Application no: H09-0053-11

Description: Proposed detached house with associated vehicular parking

Location: Adjacent 3 Chapel Street
Holbeach
Spalding
Lincs

Amendment: Include landing window and change bricks to Hanson
Malvern Village mixture (dwg. no. 1645/07)

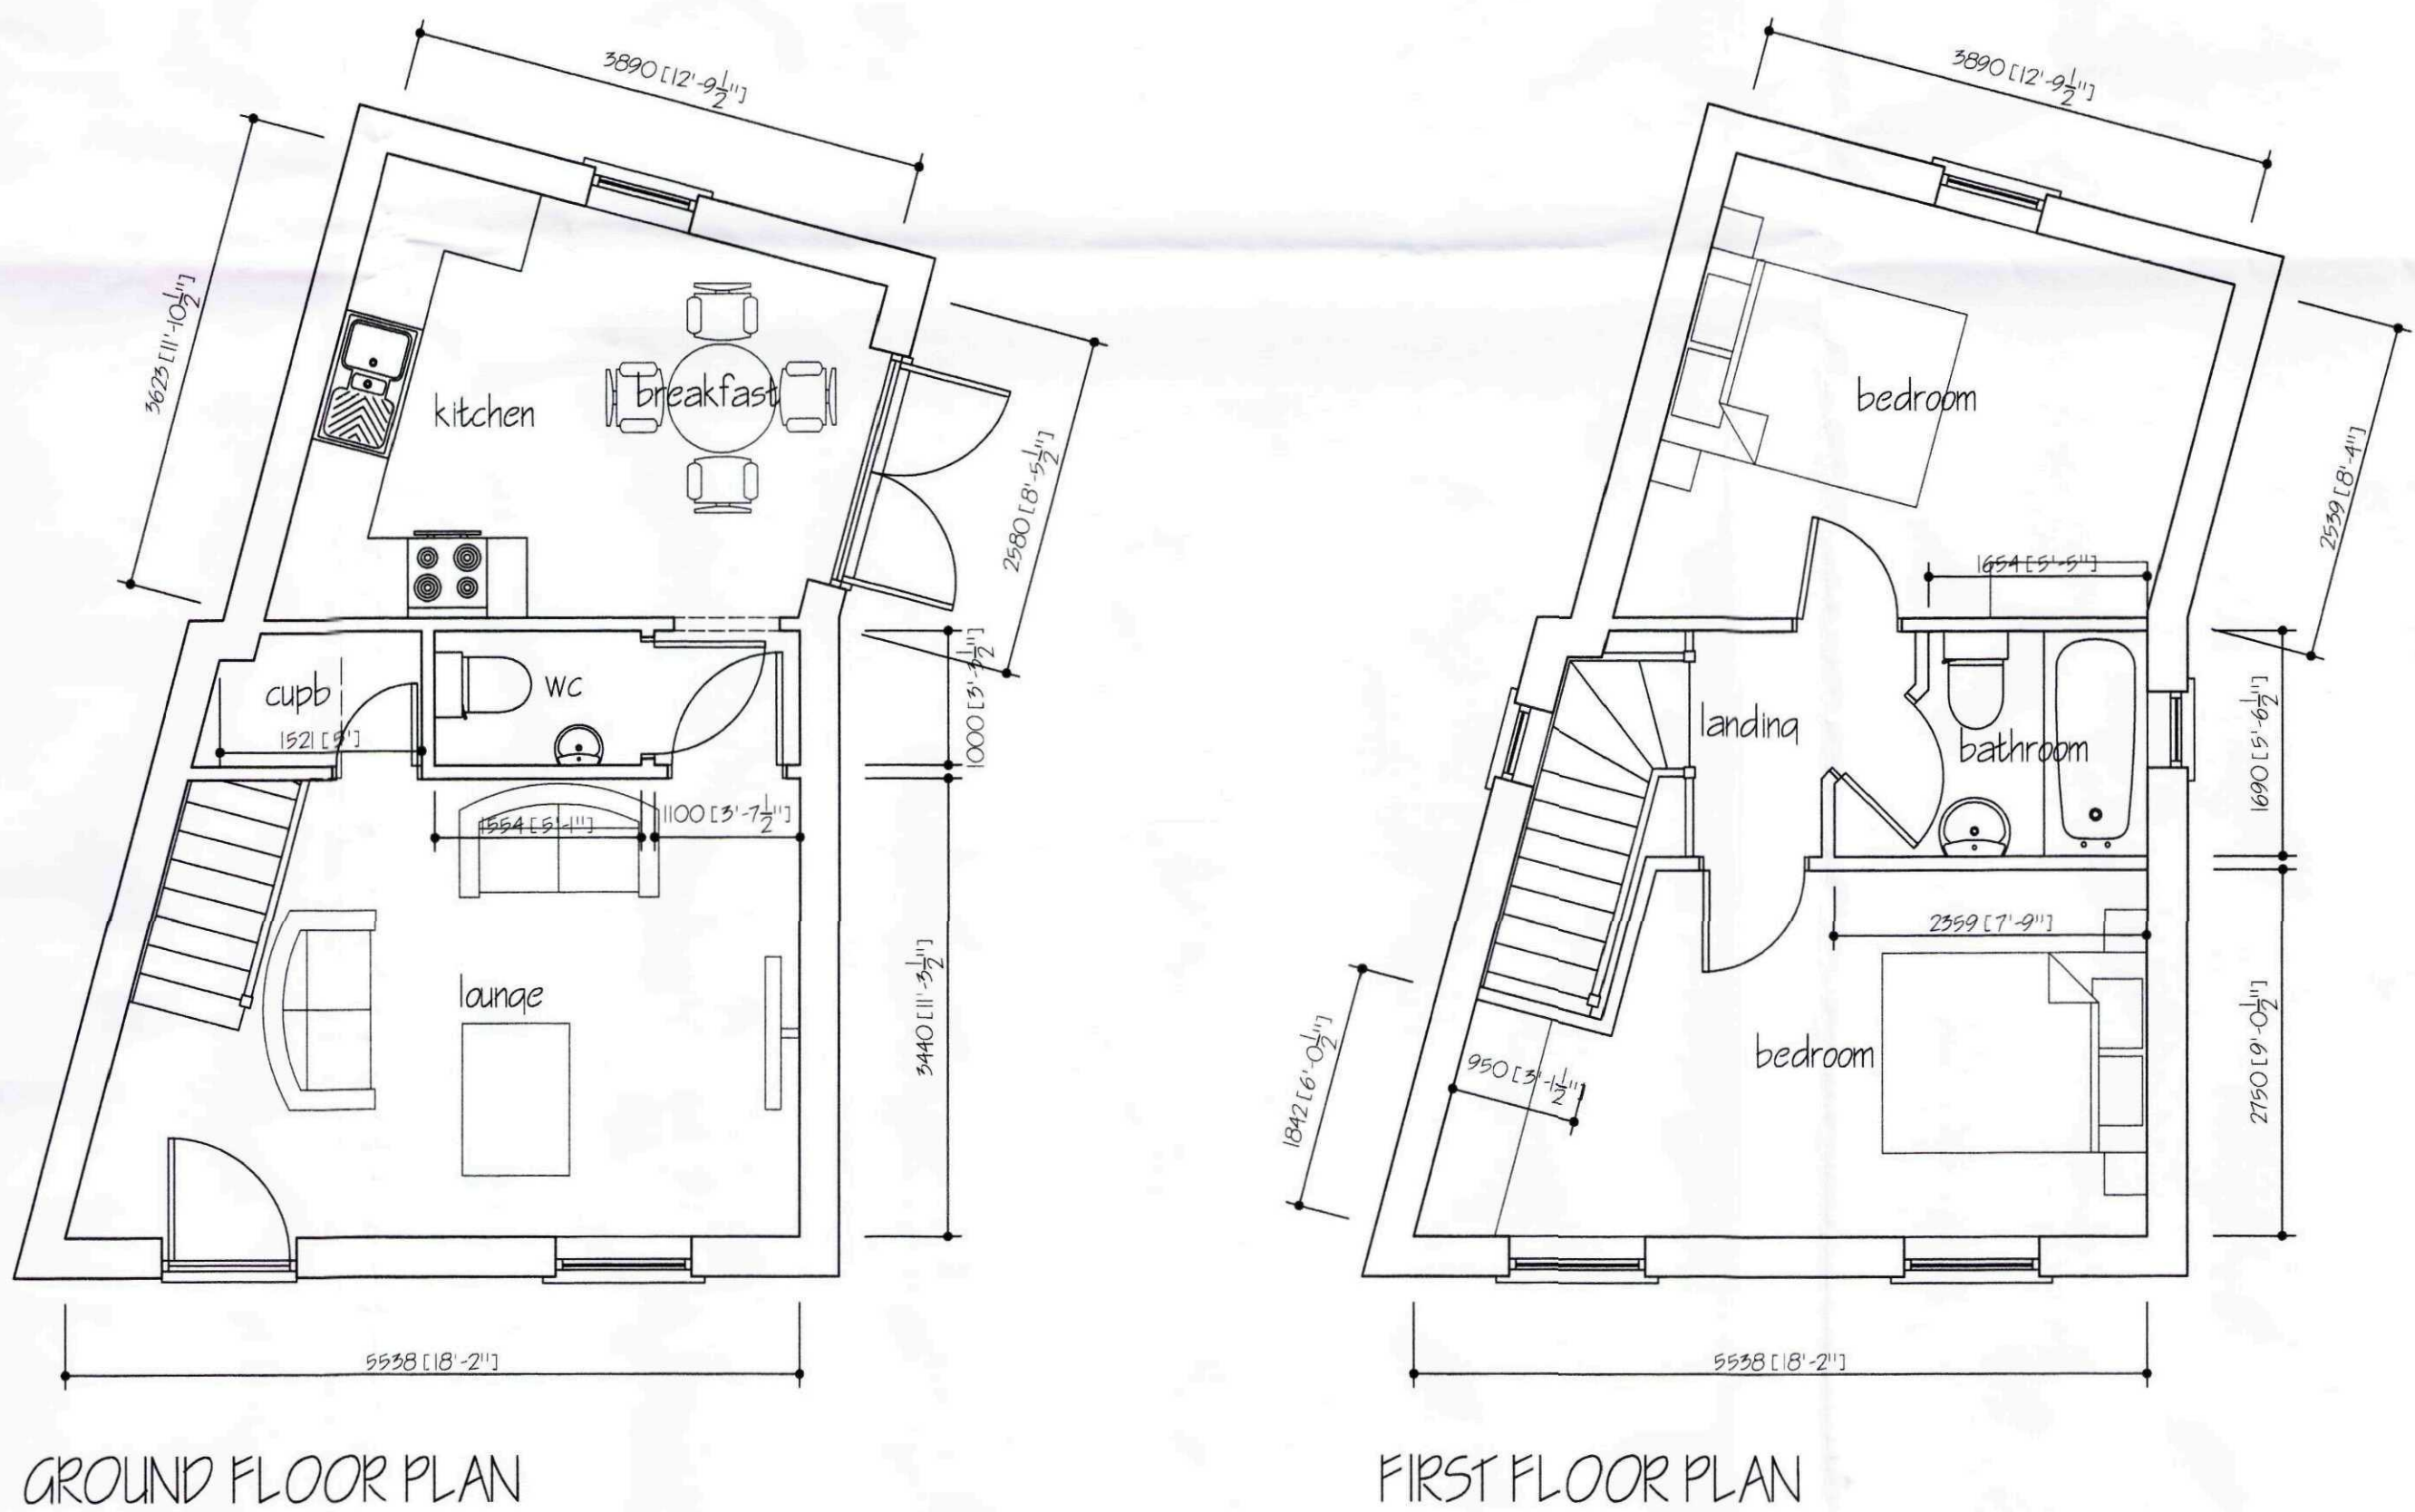
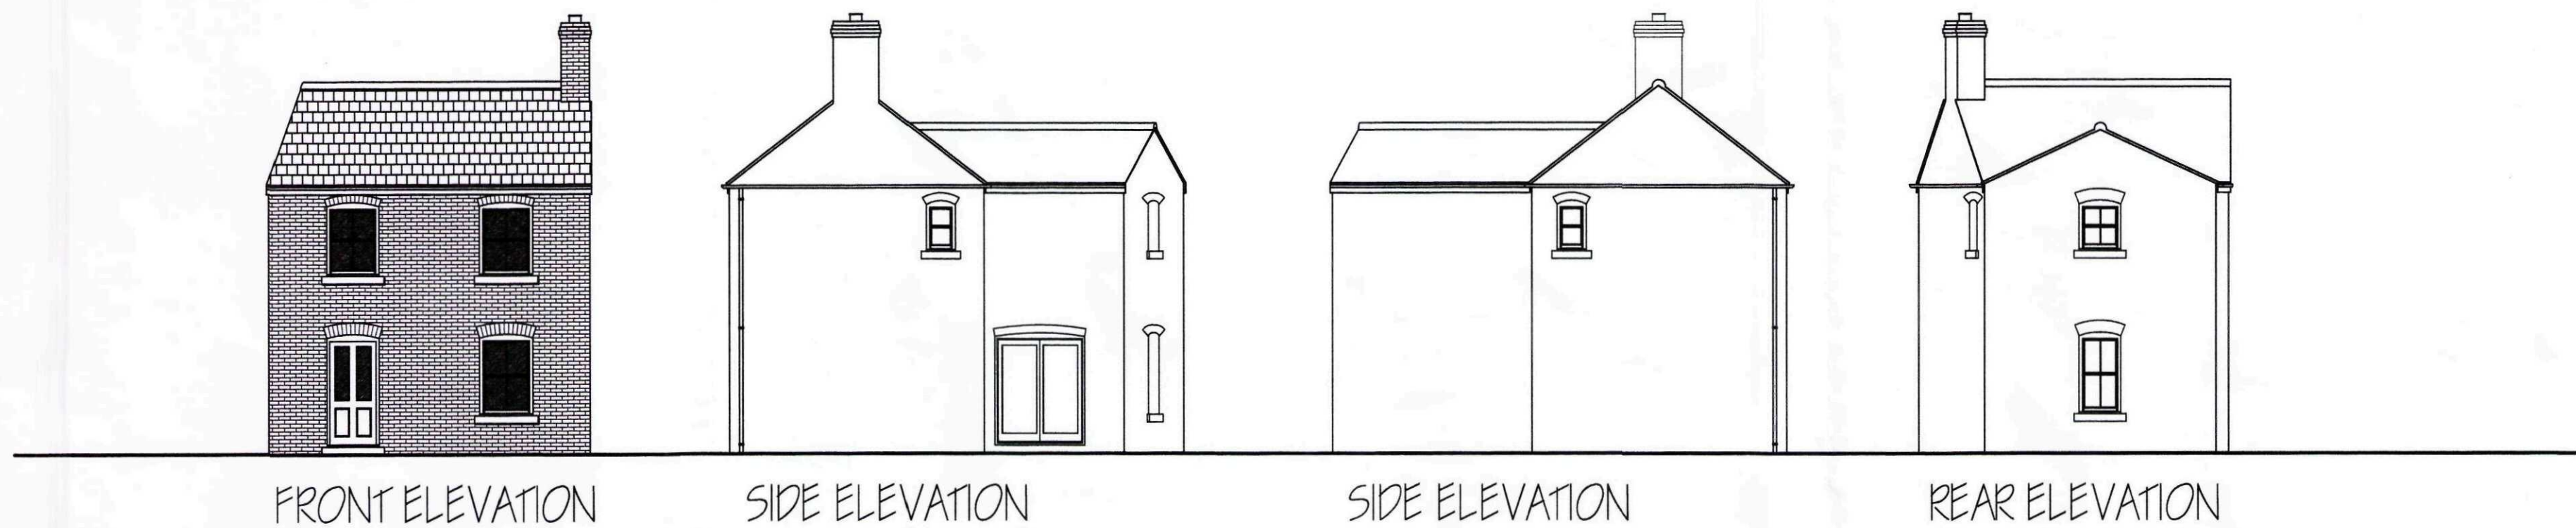
With reference to the above please find enclosed a copy of the amended plan as we missed off the landing window from the elevations.

Also our client wishes to change the bricks to Hanson Malvern Village Mixture.
